**RE: Sydney Grammar School, Weigall Sports Complex: State Significant Development (SSD-10421):  
Response to Condition B1**

This letter on the Sydney Grammar School Weigall Sports Complex (SSD-10421) is written on behalf of Sydney Grammar School. It responds to SSD-10421 Condition B1 which states:

- B1. Prior to the issue of any construction certificate, the design of Building 1 (Sports Complex building) must be amended and revised architectural plans and documentation demonstrating compliance with the condition must be submitted to, and approved by, the Planning Secretary. The revised design must modify the design of that part of Building 1 located directly opposite 8 Vialoux Avenue (i.e. the building component east of the Building 1 stair core/Multipurpose Hall 4 and including the area above the program pool) to reduce the view loss impact experienced by the north facing living rooms within apartments 1, 5, 8 and 12 at 8 Vialoux Avenue. The amendments to the design must comprise (unless otherwise agreed with the Planning Secretary) the following:

EAST ELEVATION
RESPONSE TO CONDITION B1

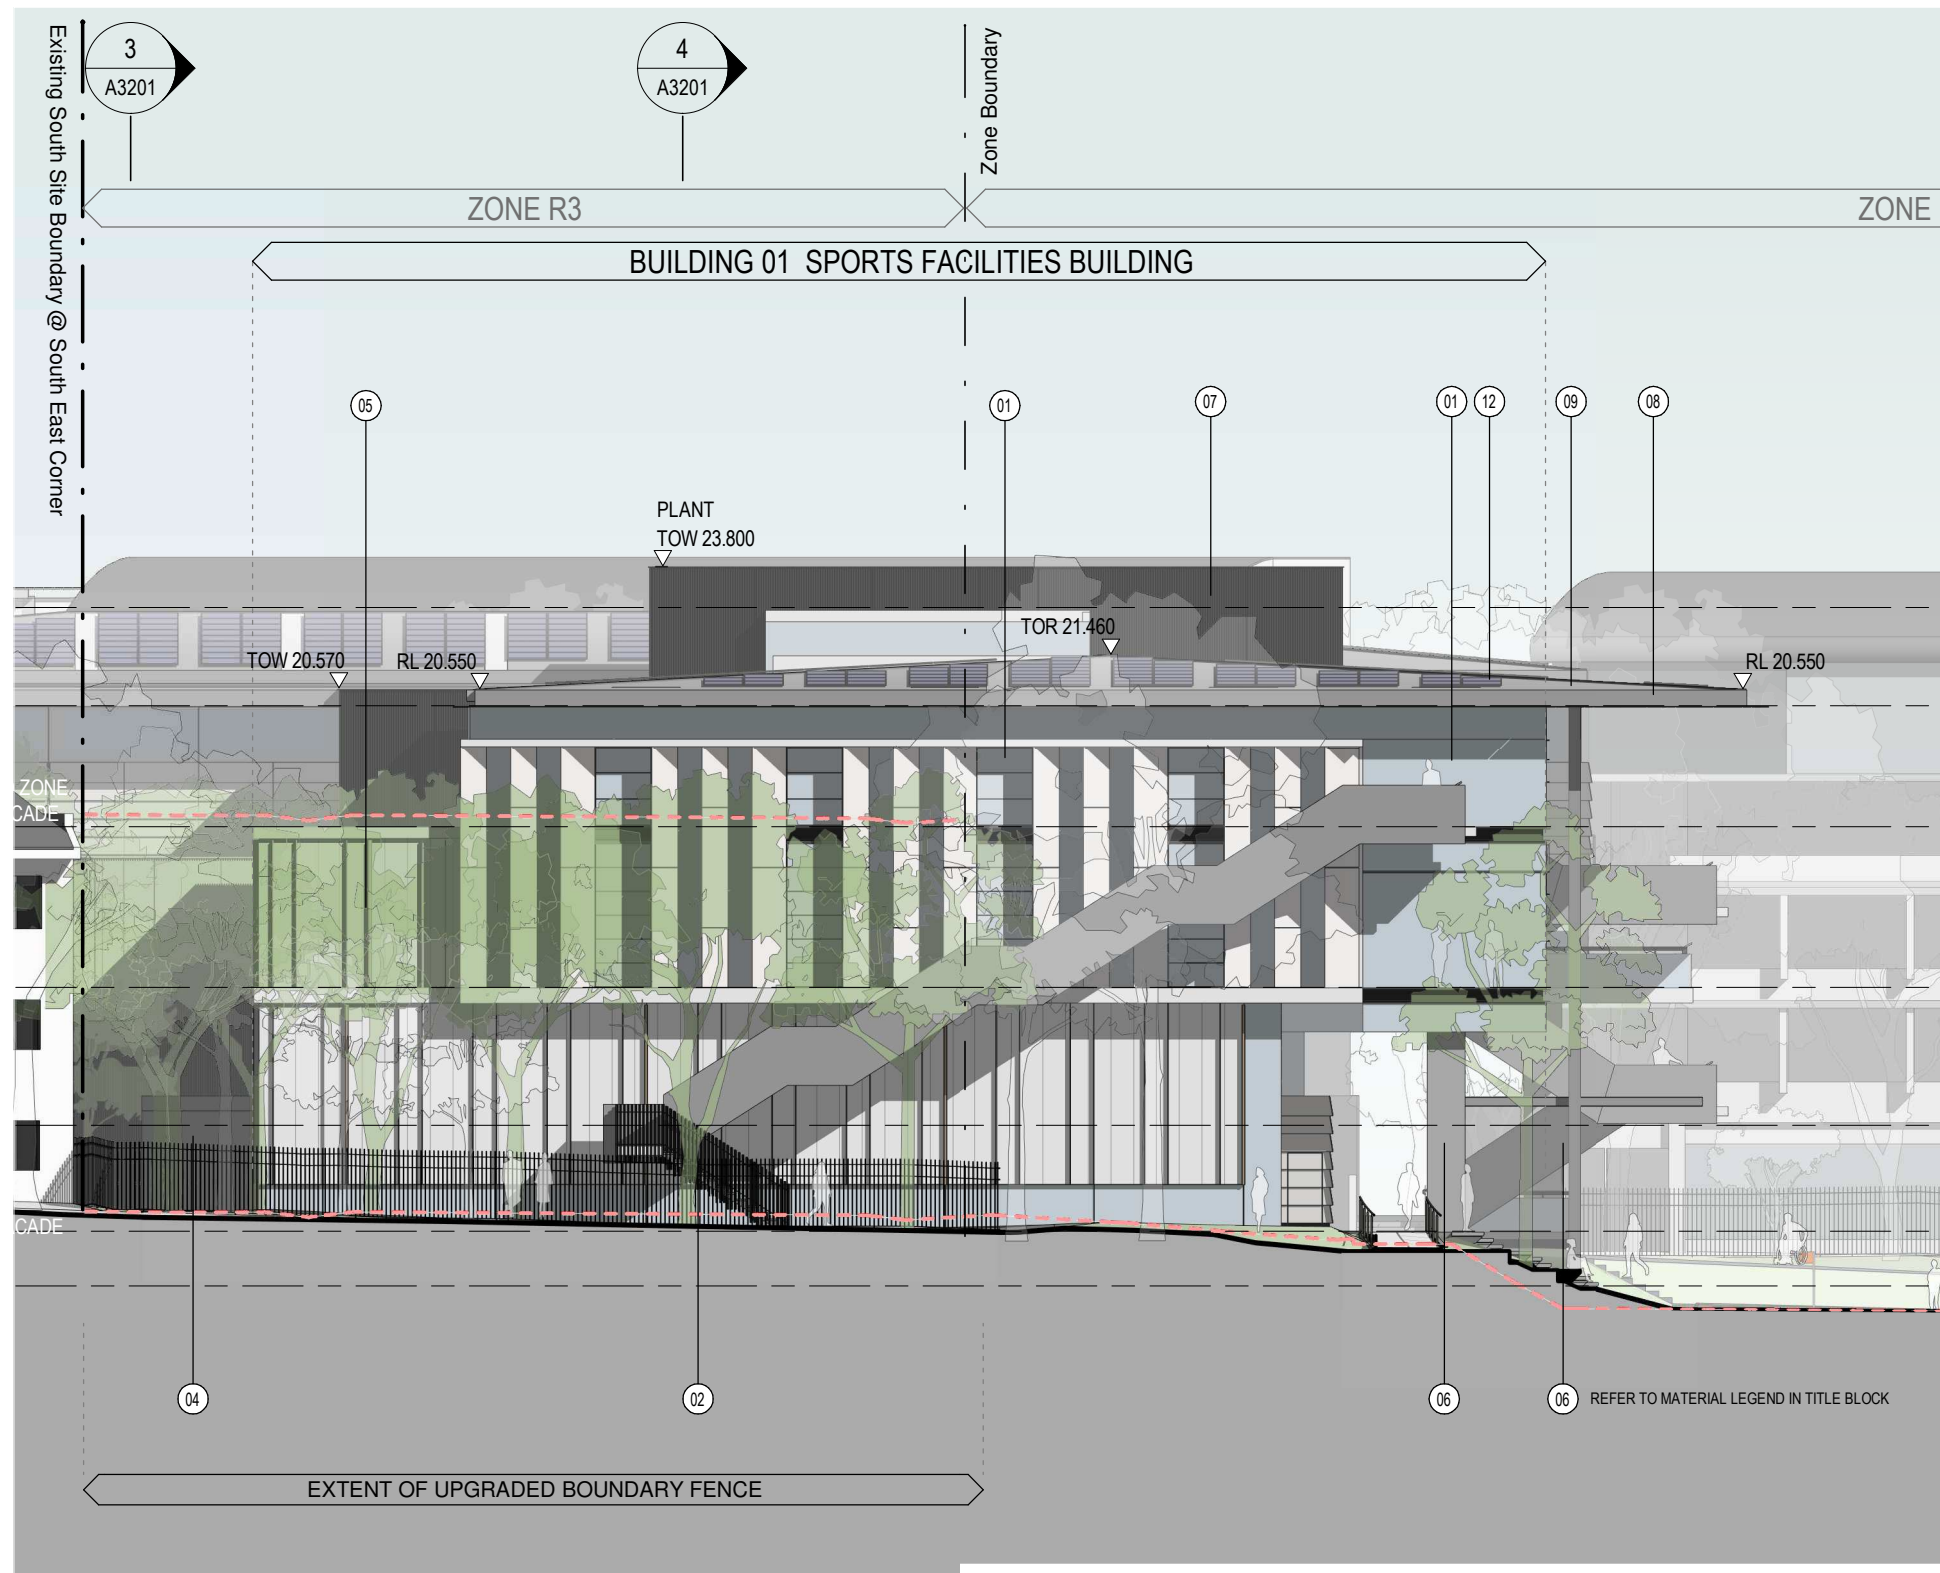
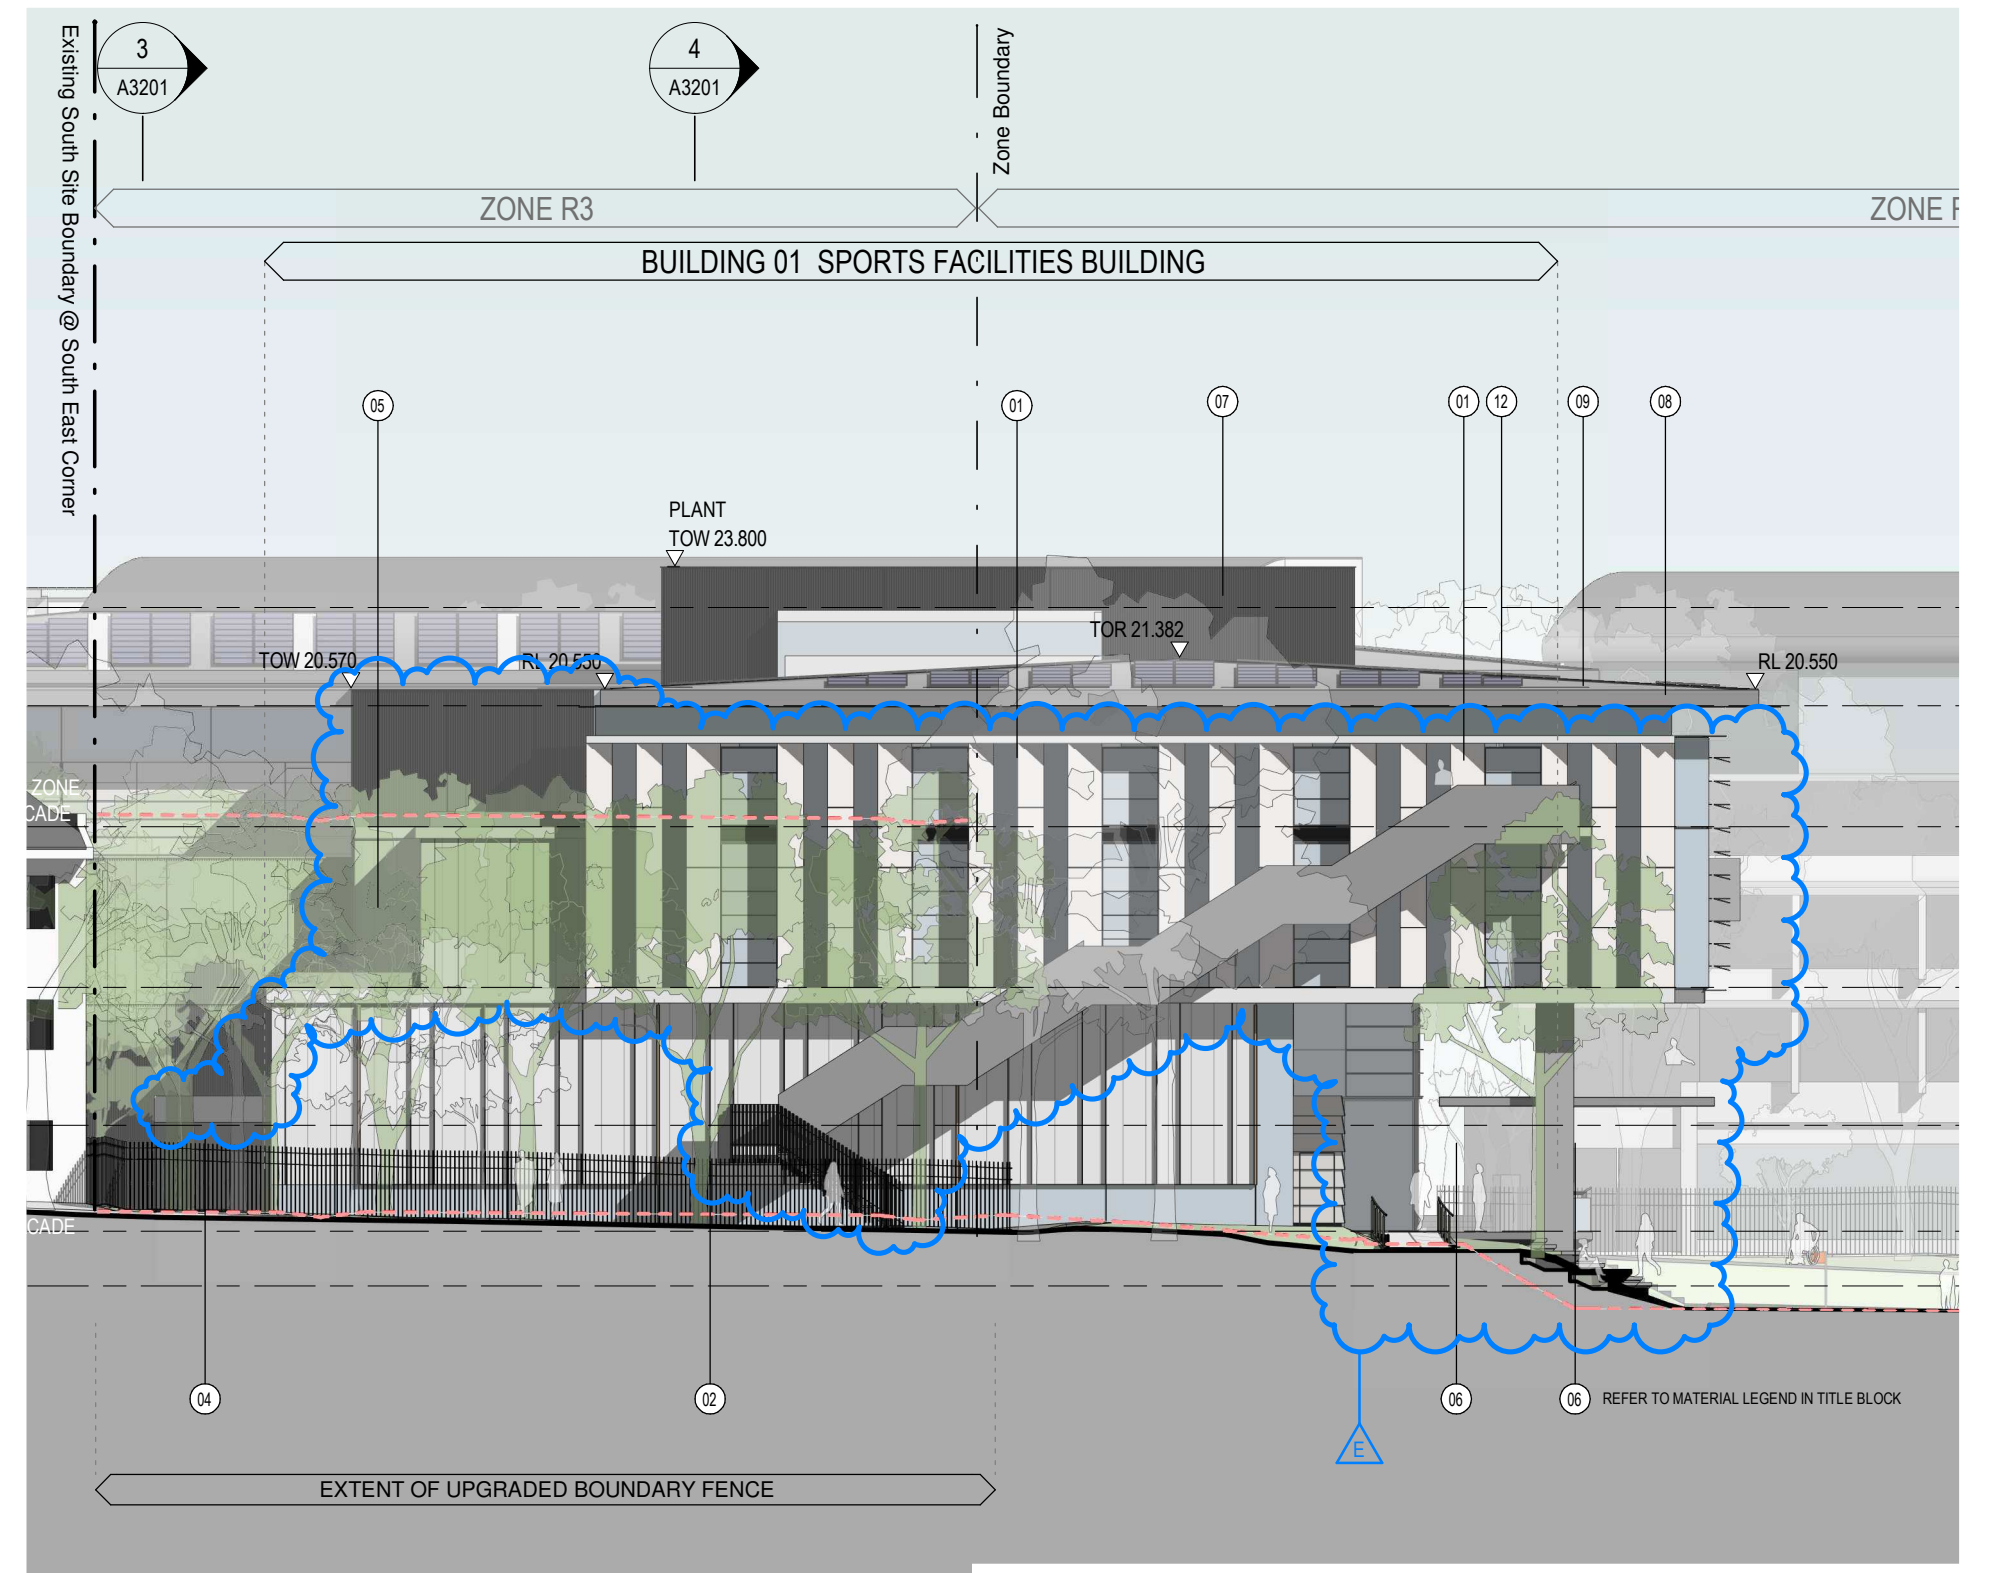
7. The spacing of concrete blades and the external stair to the Eastern Elevation facing Vialoux Avenue has been adjusted in response to Design Amendments 1, 2 and 3.
8. Amendment of the Landscape Plans to show Non Trafficable Extensive Green Roofs to the new Building 1 setback terraces adjoining the southern site boundary and minor landscape refinements to reflect the Condition B1 Design Amendments. There is a very minor change to the deep soil area (-41m<sup>2</sup>), as summarised in **Table 2**.
